PLANNING CONSULTATION RESPONSE

Application No	2025/0610
Proposal	Development of five residential dwellings and associated infrastructure
Address	Vernon House, Yews Lane, Kendray, Barnsley, S70 3LJ
Date of Consultation Reply	12 th August 2025
Consultee	Highways DC

- PROPOSED ROAD PROFILE (STRAIGHT)
- EXISTING GROUND
- HOUSE

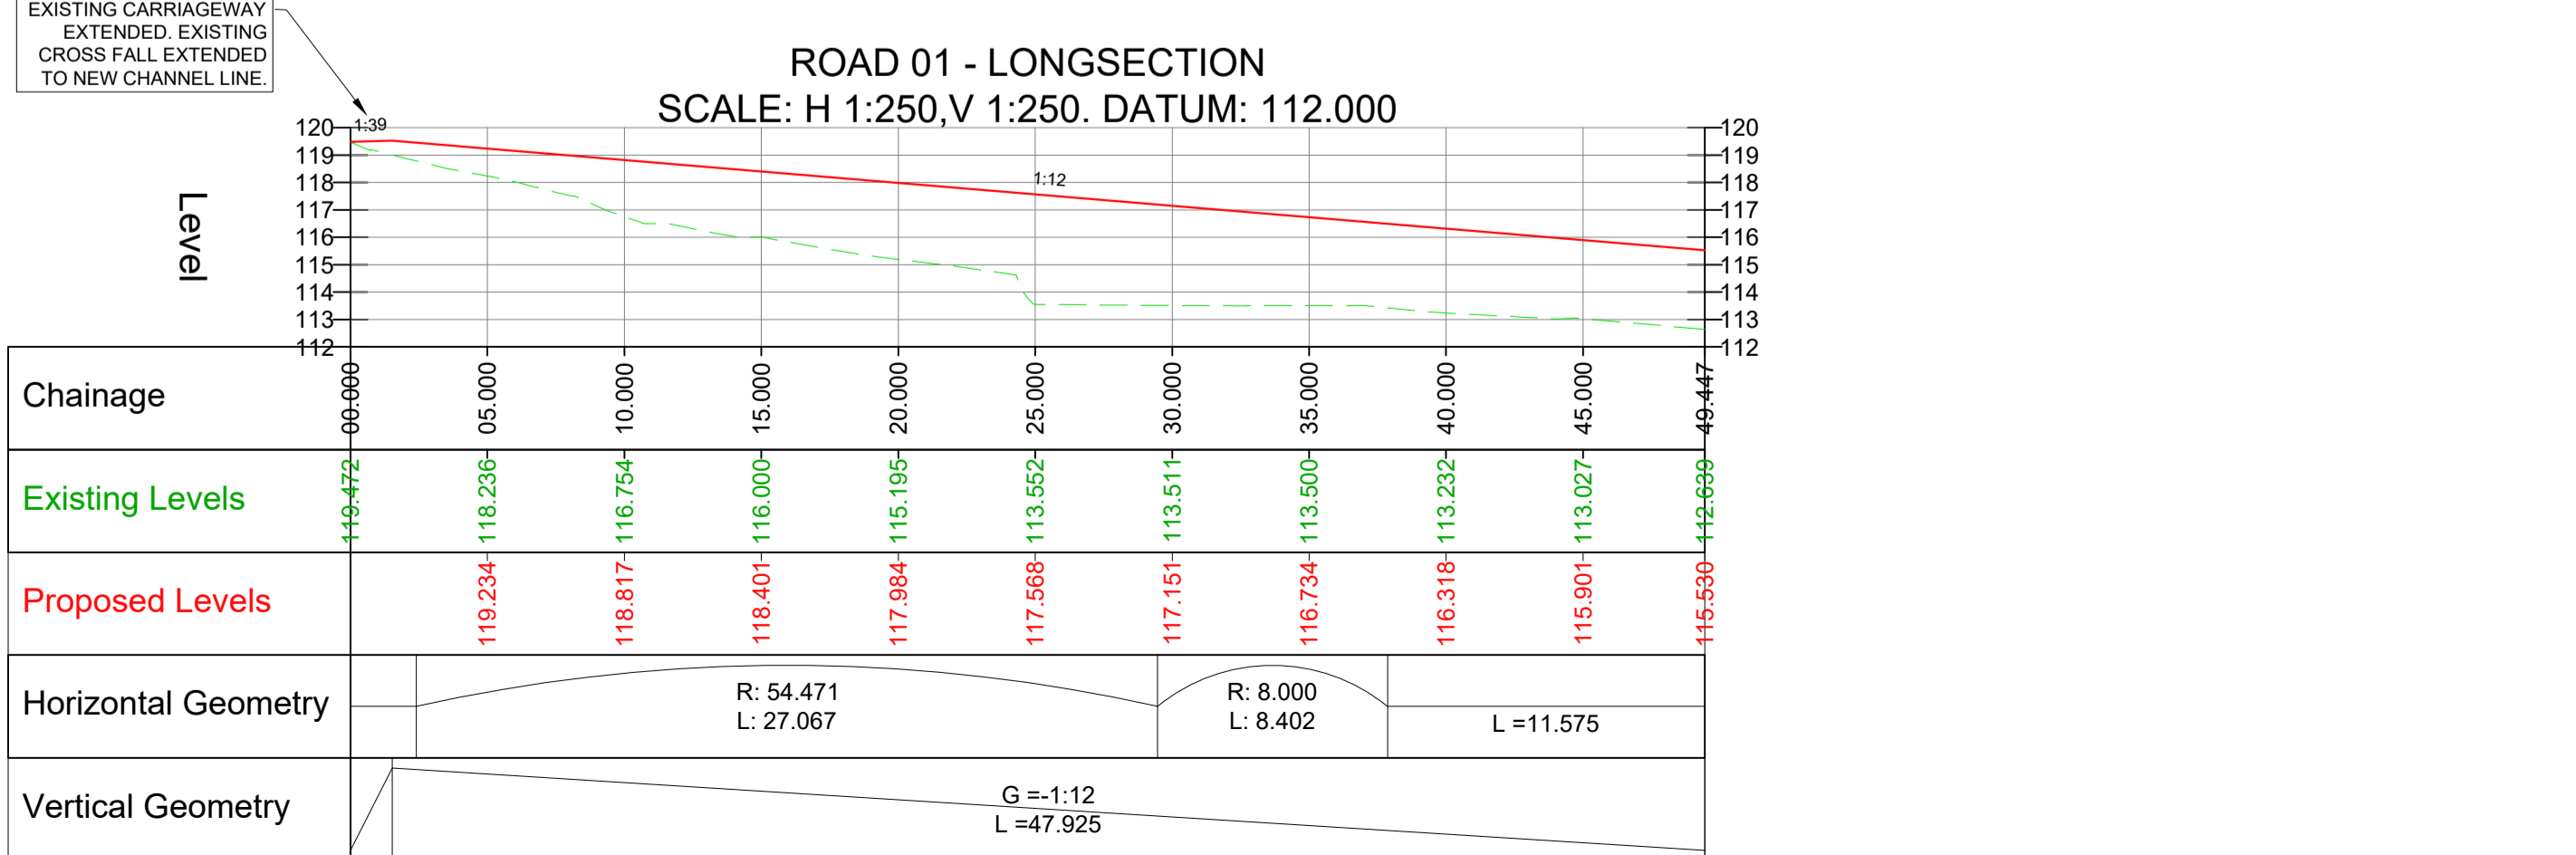
The report states that these sight lines are achievable. However, the 'Visibility Splays from Site Access' drawing contained within Appendix D includes sight lines that have the 'x' distance incorrectly shown. The 2.4m 'x' distance must be measured back from the edge of the proposed carriageway, not the existing edge.

It is likely that the proposed bin store would impede visibility when the sight lines are drawn with the correct 'x' distance.

Also, it is noted that the sight line to the right (South) encroaches into land outside of the red line boundary and therefore presumably outside the control of the applicant; as such, the provision of the sight line could not be ensured.

The proposed site access is shown to have a gradient of 1:8, this exceeds the maximum permitted gradient of 1:12.
